June 30, 2017

Ms. Helen Donaldson
City of Portland Planning Authority
4th Floor, City Hall
389 Congress Street
Portland, ME 04101

**RE: AC Hotel Portland
Plan Set Revision Summary**

Plan Set Sheet Revision / Update Summary

4 GRANITE STEPS & HANDRAILING

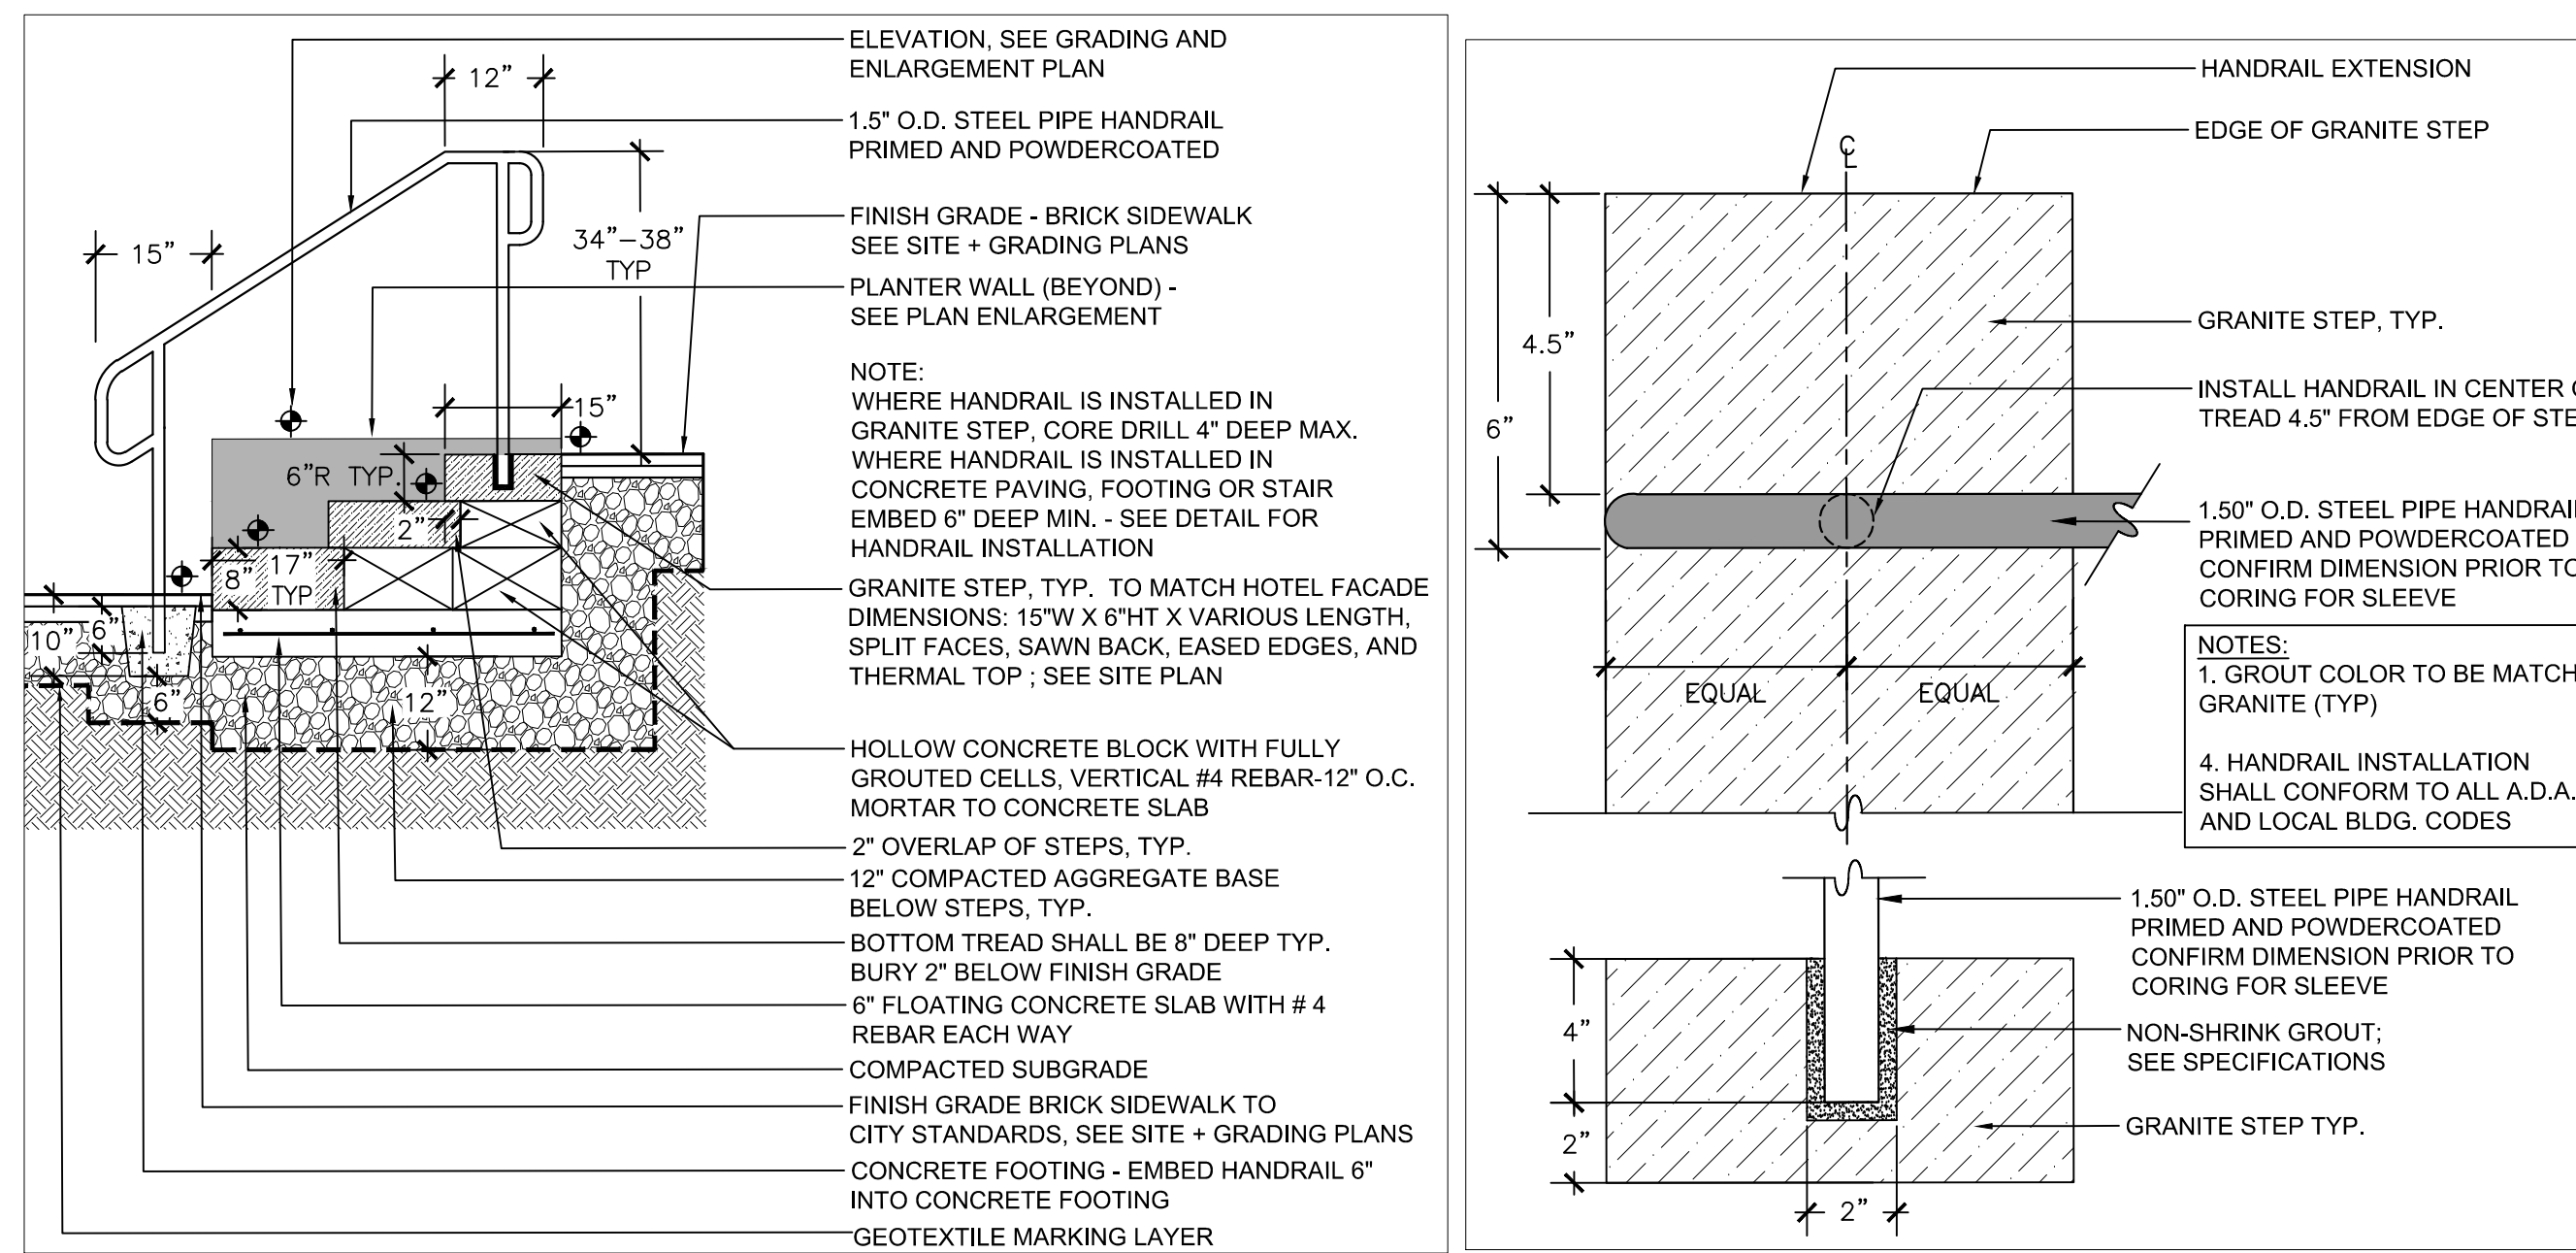
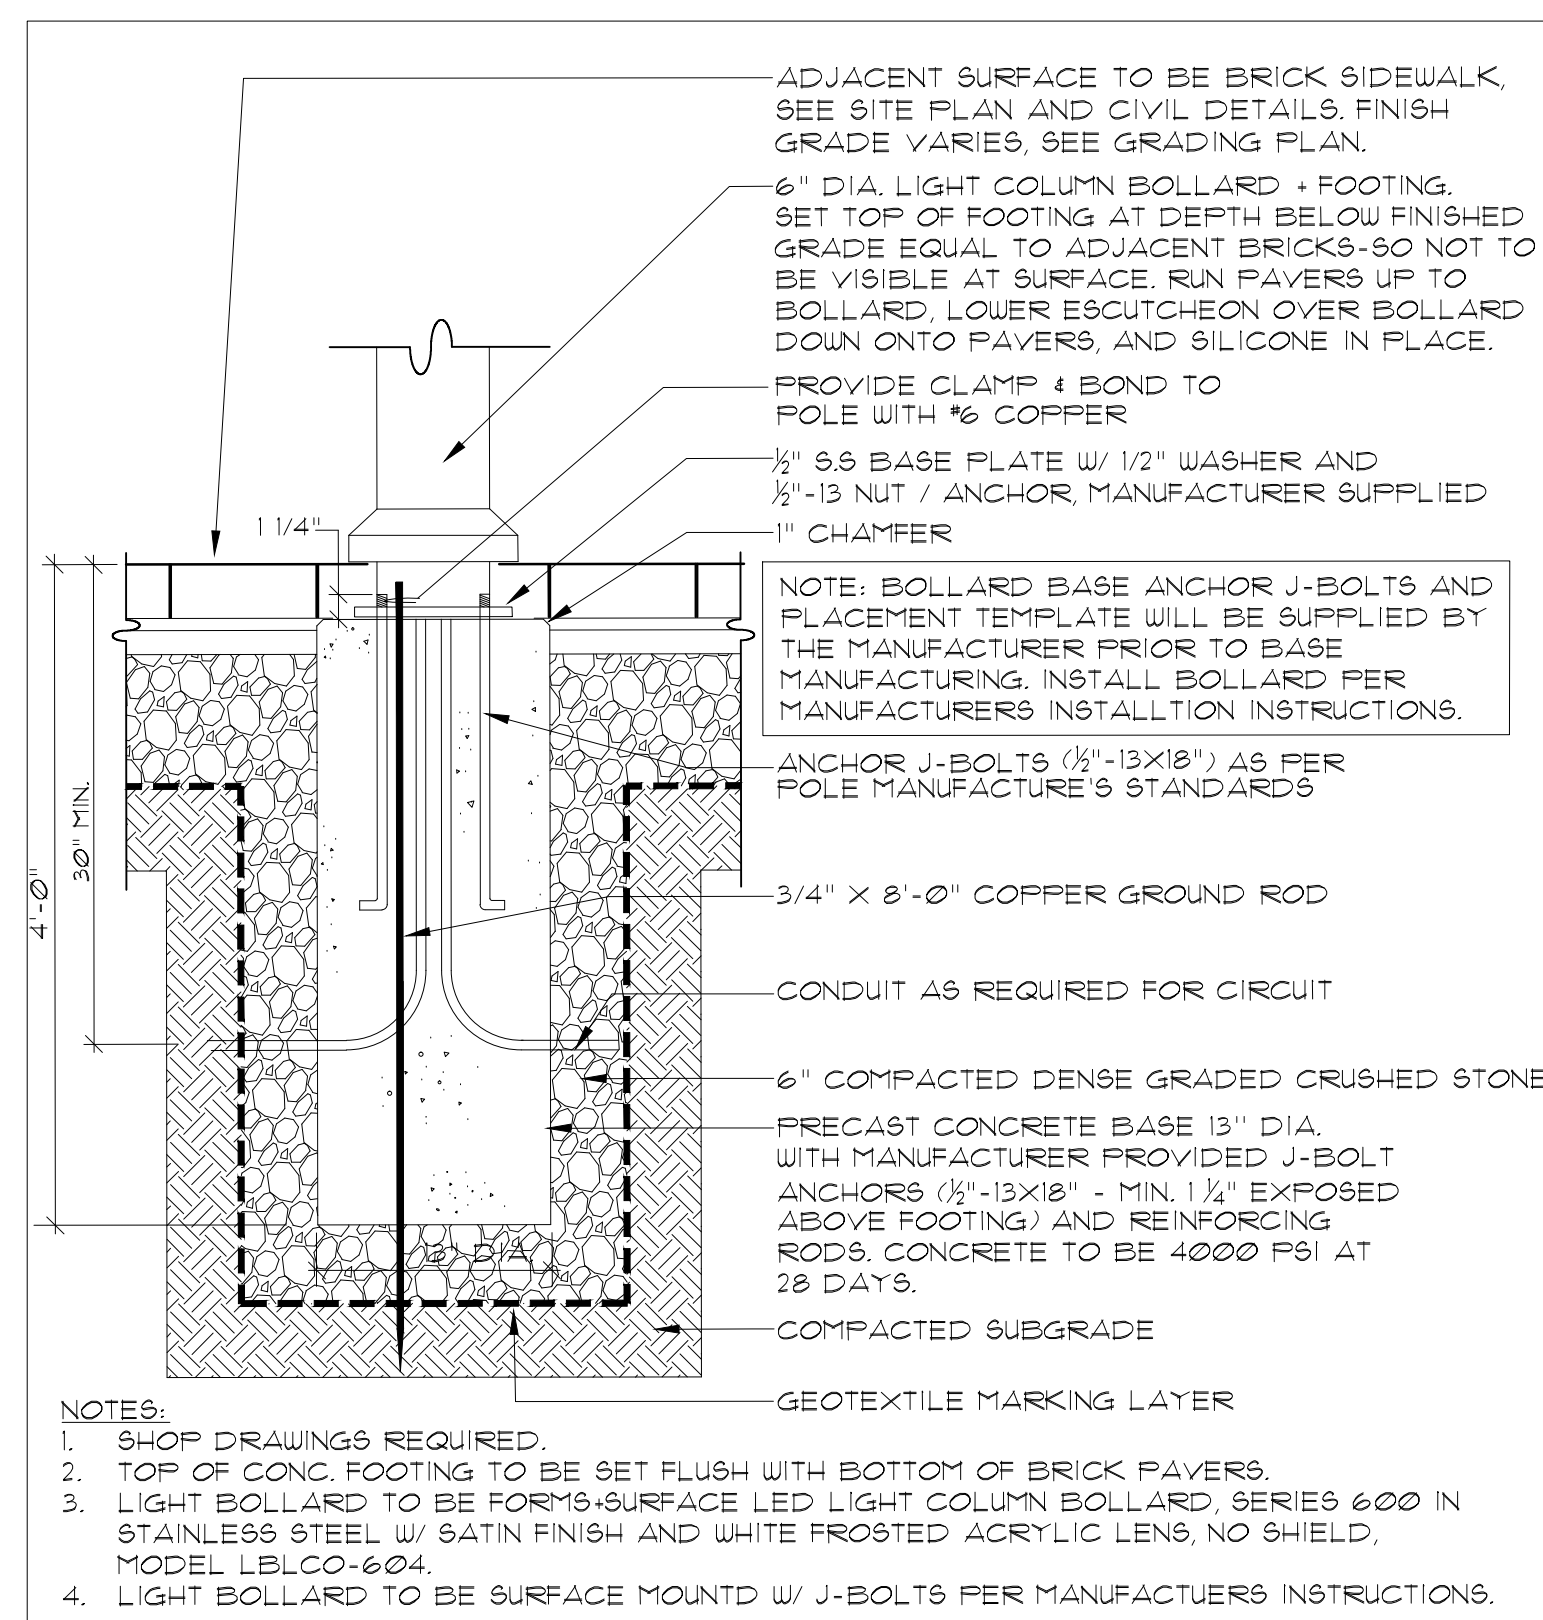
Revisions: Update Thames Street steps and handrail detail. Add Thames Street granite seatwall details. Update granite bench finish info and shape.

Revisions: Add light bollard installation details (2) and street light installation detail.
